RE: ENGINEER CERTIFICATION FOR OUR LADY OF PERPETUAL HELP
BYZANTINE CHURCH ADDITION (J18-D28) CERTIFICATION STATEMENT
DATED 6/24/96.

**RE: OUR LADY OF PERPETUAL HELP BYZANTINE CHURCH (J18-D28)
GRADING AND DRAINAGE PLAN SUBMITTAL FOR BUILDING PERMIT AND
SO-19 APPROVAL. ENGINEER'S STAMP DATED 8-11-95.**

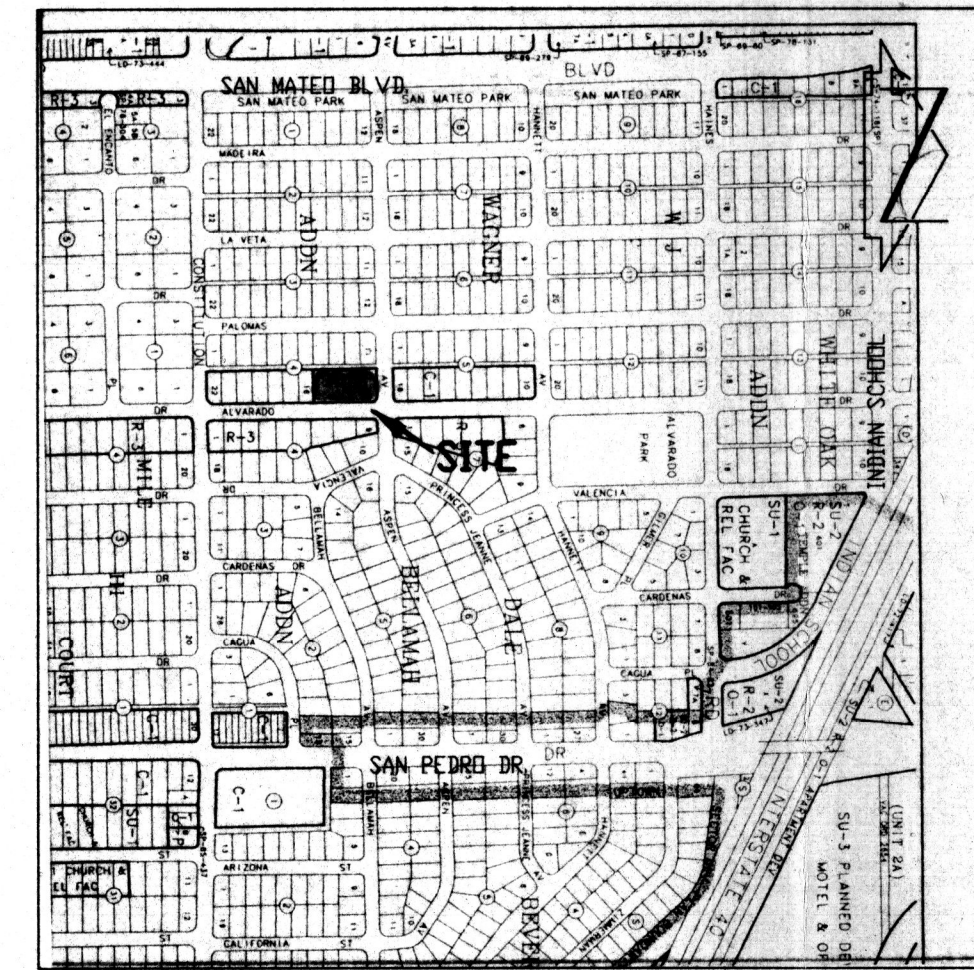
Please note, a portion of the trickle channel located on the east side of the addition slopes at 0.40%. I believe that if you raise the elevation where the trickle channel intersects with the new concrete sidewalk, your slope will increase. An increase of 0.02 feet in this area may be sufficient to make the channel slope at 0.5%.
